CITY OF ALBUQUERQUE

Re: Crestline Plastics
2635 Baylor Drive SE
Traffic Circulation Layout
Architect's Stamp 08-25-2020 (M16-D044)

Based upon the information provided in your submittal received 08-27-2020, the above referenced plan cannot be approved for Building Permit until the following comments are addressed:

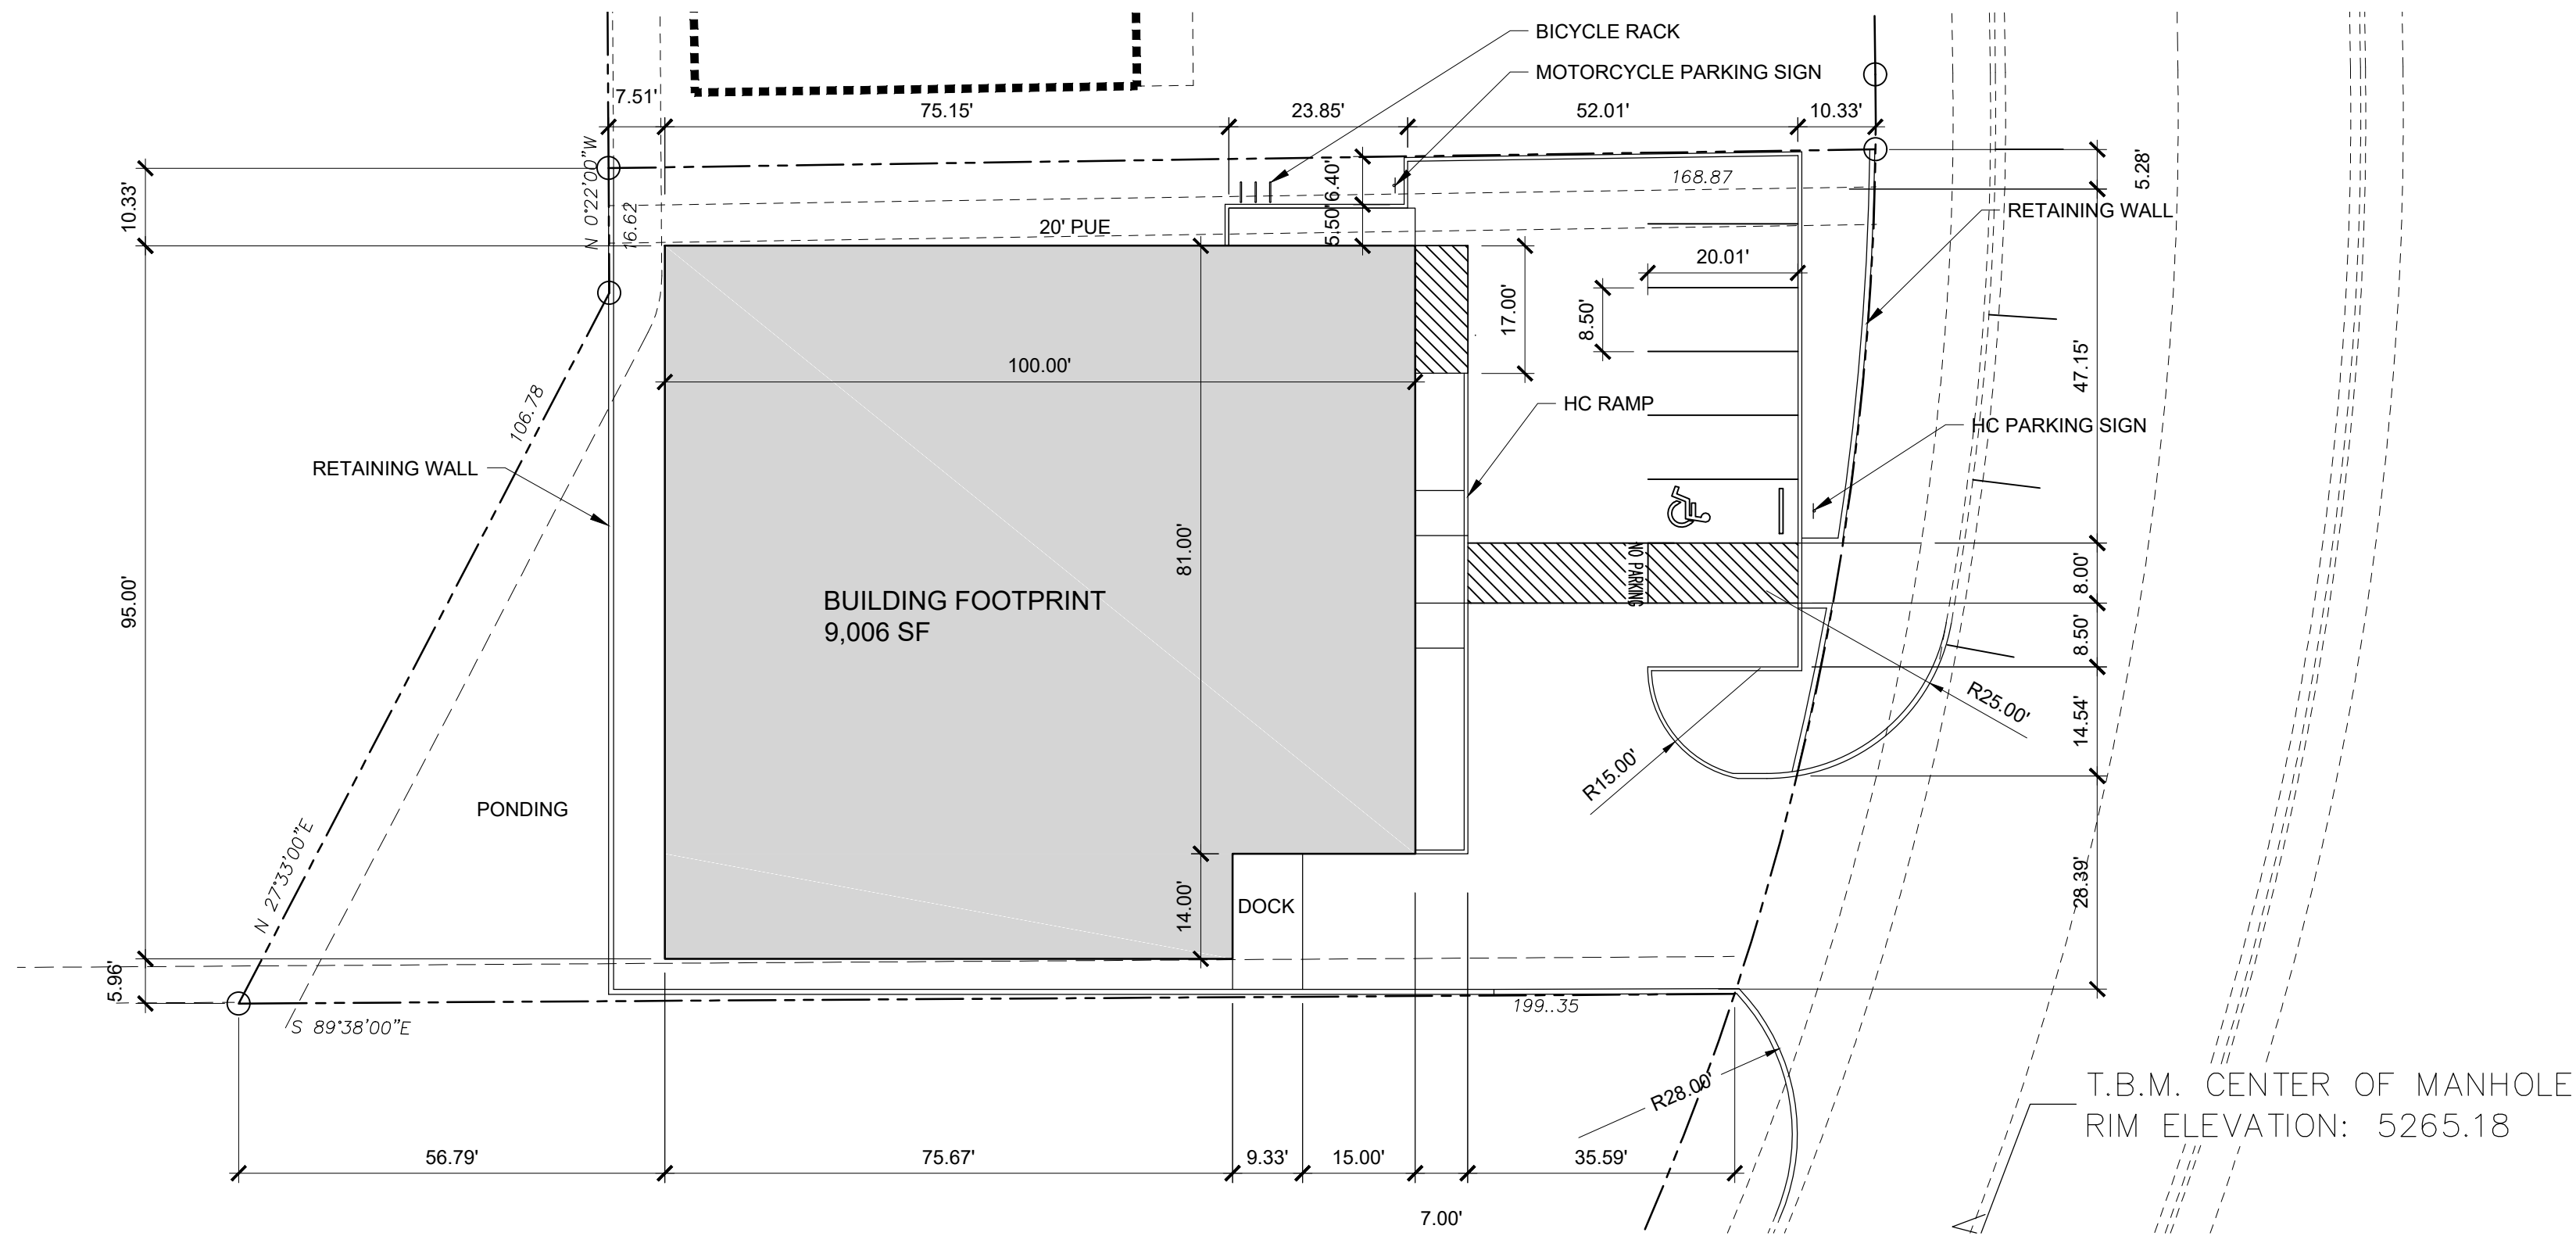
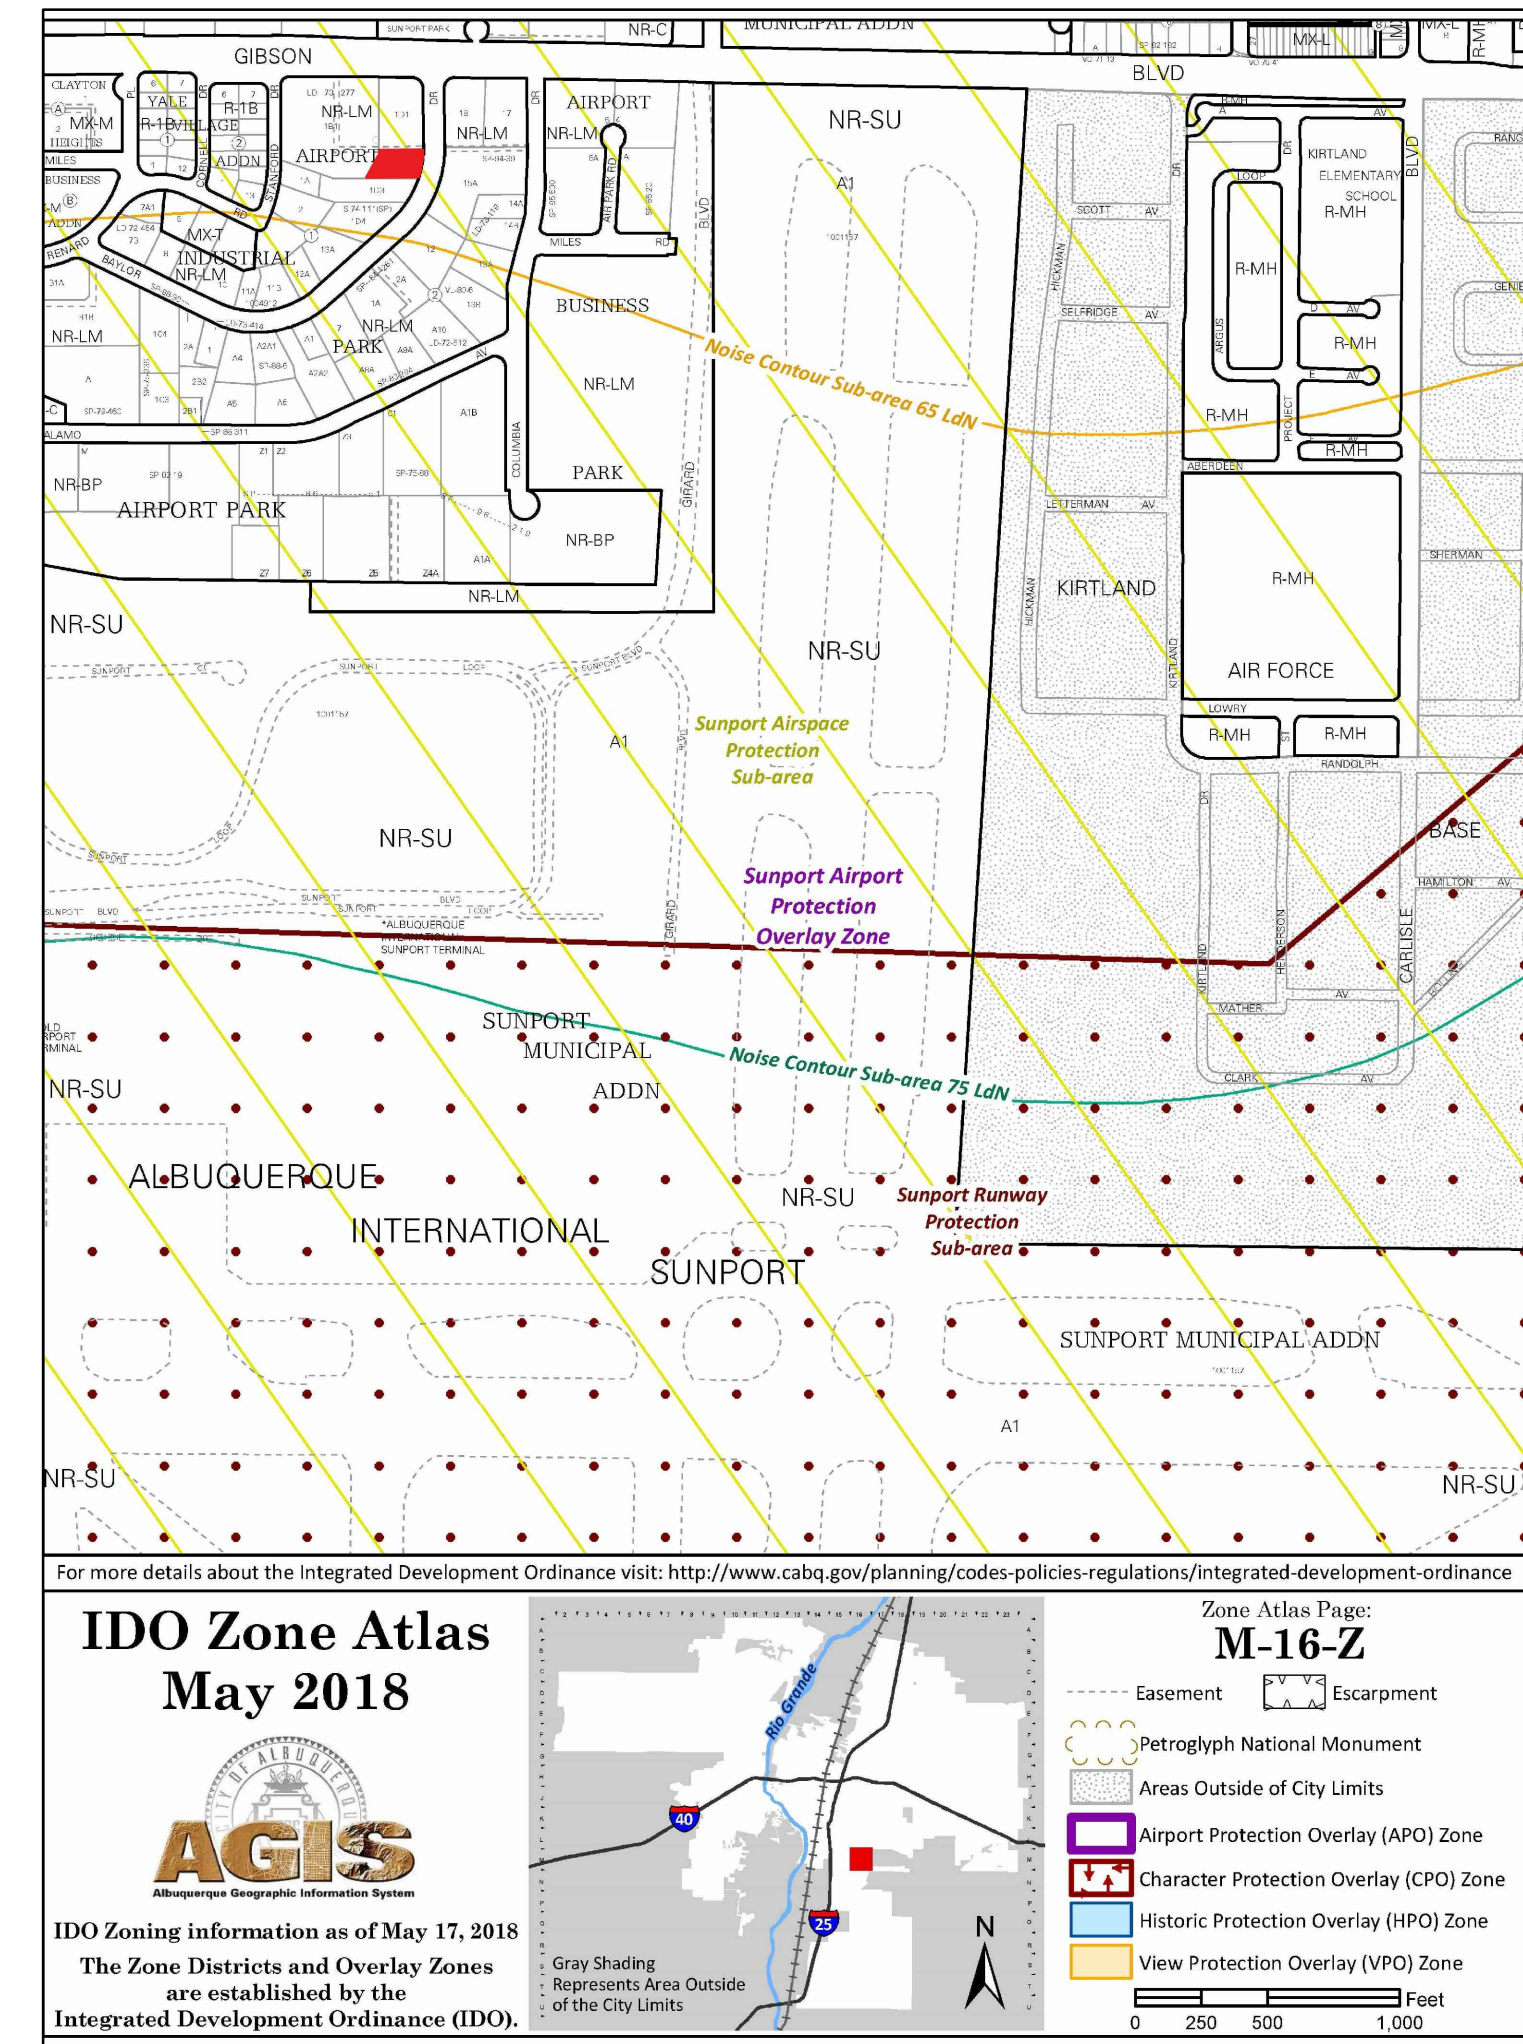
1. List the number of parking spaces required by the zoning code as well as the proposed number of parking spaces including bicycle and motorcycle parking. All proposed required calculations need to be **discussed/coordinated** with Zoning.
2. Identify the right of way width, and street provide the name of the street.
3. Maximum access width for arterial, collector, and local streets are as follows:

- Maximum allowable entrance will be 30 ft. per requirements above.
4. Please list the **width** and **length** for proposed parking spaces. Some dimensions are not shown.
 5. The minimum parking stall dimensions are:

6. The ADA accessible spaces must include an access aisle. Van accessible aisles should be 8ft wide; all others should be 5ft wide.
7. The ADA accessible parking sign must have the required language per 66-7-352.4C NMSA 1978 **"Violators Are Subject to a Fine and/or Towing."** Please call out detail and location of signs.

8. The ADA access aisles shall have the words **"NO PARKING"** in capital letters, each of which shall be at least one foot high and at least two inches wide, **placed at the rear of the parking space** so as to be close to where an adjacent vehicle's rear tire would be placed. (66-1-4.1.B NMSA 1978)

9. ADA curb ramps must be updated to current standards and have truncated domes installed (**Reference this standard COA std dwg 2441**). So General Notes – TCL no. 3 need to reflect 2441 not 2425.

10. Keyed Note 12 doesn't reflect what is being marked. Please clarify.
11. Keyed Note 21 should read 2441 not 2442.
12. All bicycle racks shall be designed according to the following guidelines(**Are these notes for bicycle rack being reflected on site plan? If not then add notes**):

16. Show all drive aisle widths and radii. Some dimensions are not shown.
17. List radii for all curves shown; for passenger vehicles. Radius for delivery trucks, fire trucks, etc. is 25 ft. or larger.

18. 5 ft. keyway: Need to provide curbing at property line.

19. Per the IDO, a **6 ft. wide ADA accessible pedestrian pathway** is required from the public sidewalk to the building entrances. Please **clearly show this pathway** and provide details(dimension 6 ft width). **The detail must include 5'x5' landing at 2% on all ramp angle turns (provide extra detail for this requirement)**.

20. Per DPM, a **6 ft. wide ADA accessible pedestrian pathway** is required from the ADA parking stall access aisles to the building entrances. Please clearly show this pathway and provide details. Provide widths.

21. Public sidewalk: provide existing widths.
22. Curbing should be installed to delineate **landscape**, parking, and **pedestrian ways** and identify points of access. Please call out detail and location of barrier curb.

23. Provide a copy of refuse approval. You have 5 yard dumpster in front of proposed parking stall! Any problems for vehicle maneuverability?
24. It is not apparent what type of pavement surface is being proposed. A hard driving surface will be required as part of this proposed project for parking area and drive aisles. Concrete will need to be 6 " minimum thickness (if proposed) for vehicle traverse.

25. Please provide a stopping/intersection sight distance exhibit (See attachment for clarity).
26. Show the clear sight triangle and add the following note to the plan:
"Landscaping and signage will not interfere with clear sight requirements. Therefore, signs, walls, trees, and shrubbery between 3 and 8 feet tall (as measured from the gutter pan) will not be acceptable in the clear sight

27. Shared Site acces: driveways that straddle property lines, or are entirely on one propertybut are to be used by another property, shall have an access easement. **Please include a copy of your shared access agreement with the adjacent property owner.**

28. Add a note stating "All broken or cracked sidewalk must be replaced with sidewalk and curb & gutter." A build note must be provided referring to the appropriate City Standard drawing.

BIKE RACK

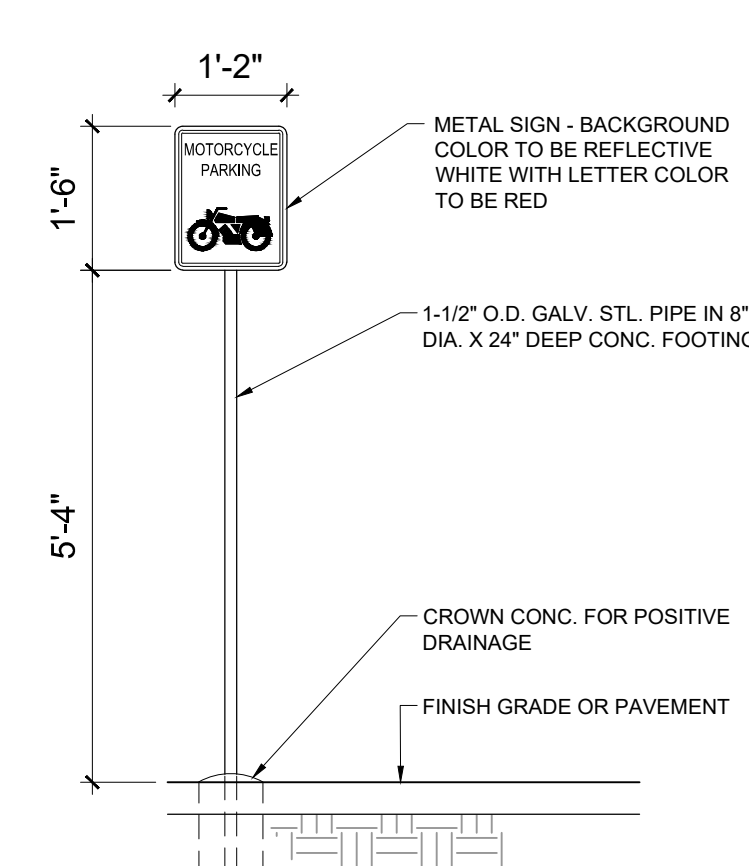
- a. The rack shall be a minimum 30 inches tall and 18 inches wide.
 - b. The bicycle frame shall be supported horizontally at two or more places. Comb/toaster racks are not allowed.

- c. The rack shall be designed to support the bicycle in an upright position. See the IDO for additional information.
 - d. The rack allows varying bicycle frame sizes and styles to be attached.

- e. The user is not required to lift the bicycle onto the bicycle rack.
 - f. Each bicycle parking space is accessible without moving another bicycle.

13. Bicycle racks shall be sturdy and anchored to a concrete pad.
14. A 1-foot clear zone around the bicycle parking stall shall be provided.
15. Bicycle parking spaces shall be at least 6 feet long and 2 feet wide.
